18 October 2016
Our Ref: 6376D.4DK_further response to submission

Section 75W Modification of Concept Plan Approval (MP06_0060) and Project Approval (MP06_0058) – Modification No. 15

Vincentia Coastal Village & District Centre, Corner of Wool Road and Naval College Road, Vincentia – Lot 6002 DP 1195858

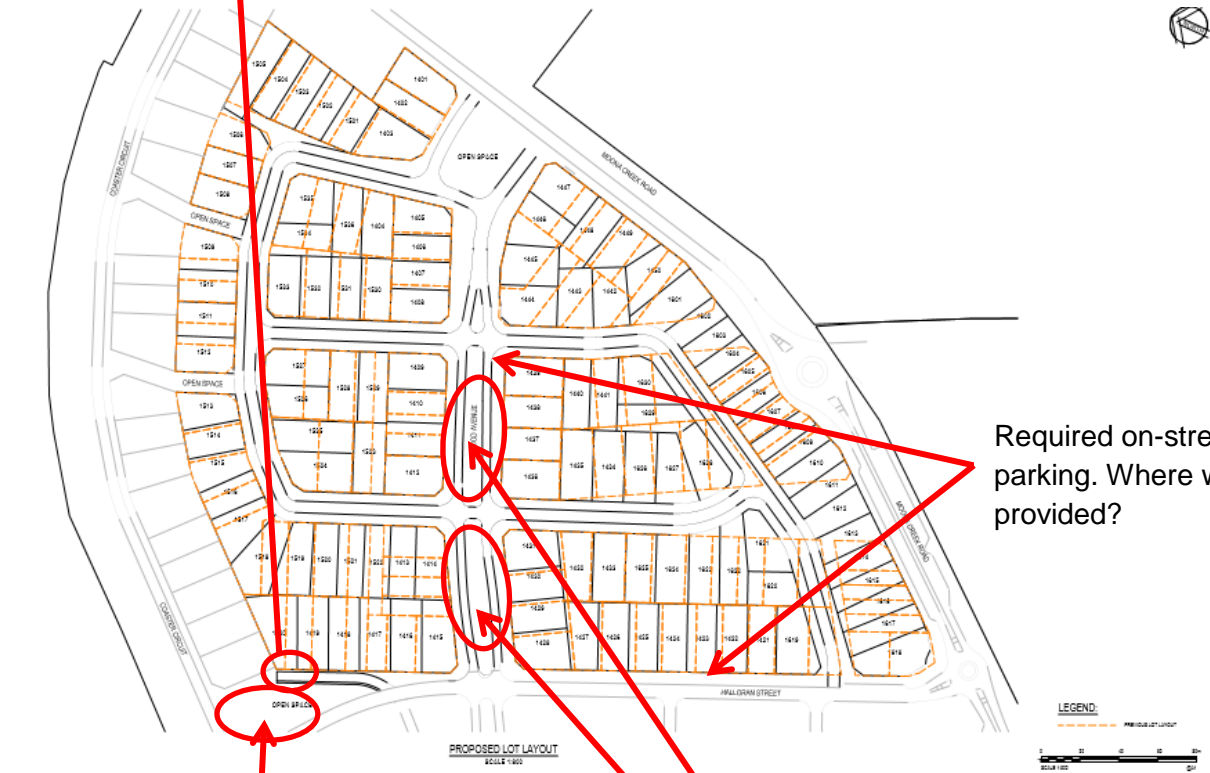
- 2 *The proponent advises that drainage will be via interlot drainage easement and will be directed through open space areas to Coaster Circuit. Clarification is sought if the easement is proposed through the open space adjacent to 28 Coaster Circuit and if so, how this will impact on existing vegetation, as it has been stated that this open space will remain in its native state?*

3. *In relation to finished surface levels of sites and driveway/turning head servicing Lots 1419-1420, the proponent has not provided any further detail other than to state that "It is not intended to significantly change the land levels of the subject site relative to 28 Coaster Circuit that would result in the proposed lot and driveways being elevated to an extent that would cause adverse amenity impacts". In this regard, it is requested that the Department condition the consent to require the driveway/turning head finished surface level to be at natural ground level.*

Inter allotment drainage is not proposed through the open space adjoining 28 Coaster Circuit. The drainage lines will be installed in the narrow open space corridors further east (i.e. between Road 1 and Coaster Circuit).

The applicant intends to grade Proposed Lot 1420 in a manner that transitions smoothly with the rear of No. 28 and 30 Coaster Circuit. The northern corner of the turning head would therefore need to be at the same finished surface level or slightly below to achieve an acceptable driveway gradient. The turning head will have a small crossfall (approximately 5%) grading back to the road to drain the driveway back to the kerb of Halloran Street. A condition requiring the turning head to be at natural ground level is not considered warranted as it will not allow water to drain to Halloran Street and may result in water draining through the open space to Coaster Circuit which will impact on existing vegetation.
